CITY OF ALBUQUERQUE

December 13, 2017

**Re: Legacy Home Healthcare
Erosion and Sediment Control Plan
Engineer's Stamp Date 12-12-17 (E12E006F)**

EROSION AND SEDIMENT CONTROL PLAN

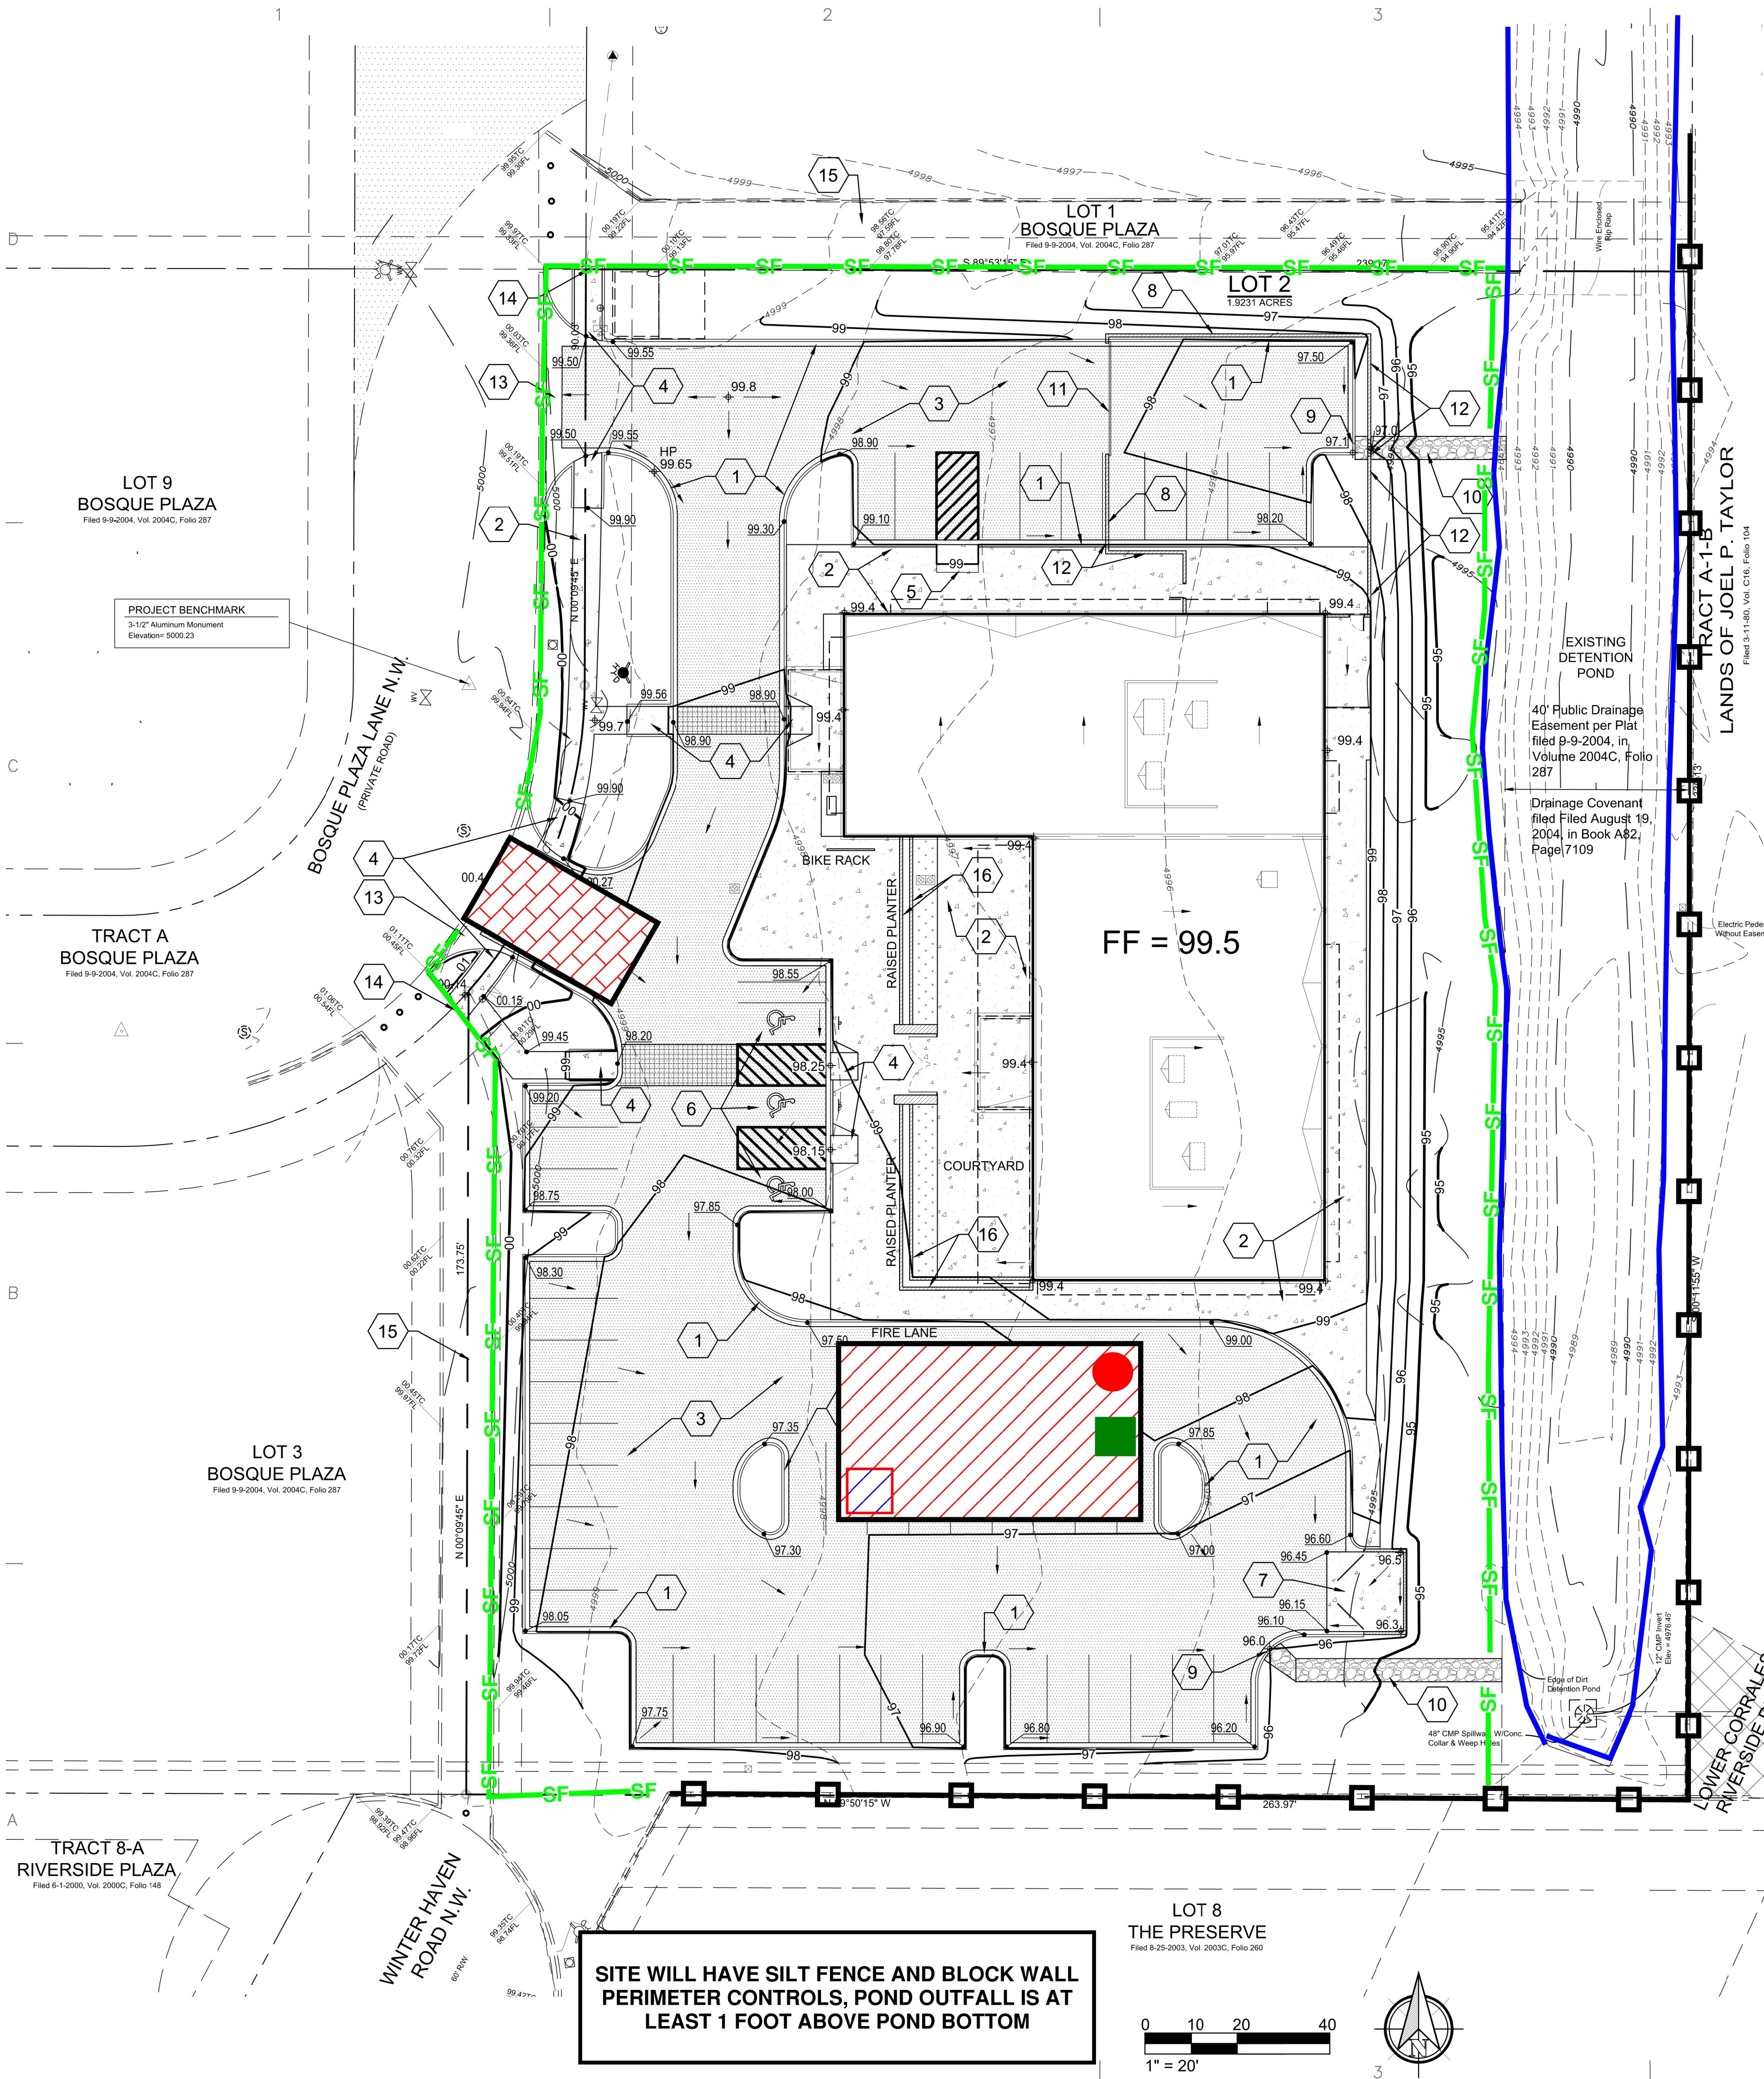
1. A sediment BMP (silt fence or filter sock) is required at the downstream end of the riprap rundowns. A sediment BMP is required along the entire eastern edge of the site.
2. Use the legend from the plan with stamp date 12-5-17, as it got shifted in the latest revision.
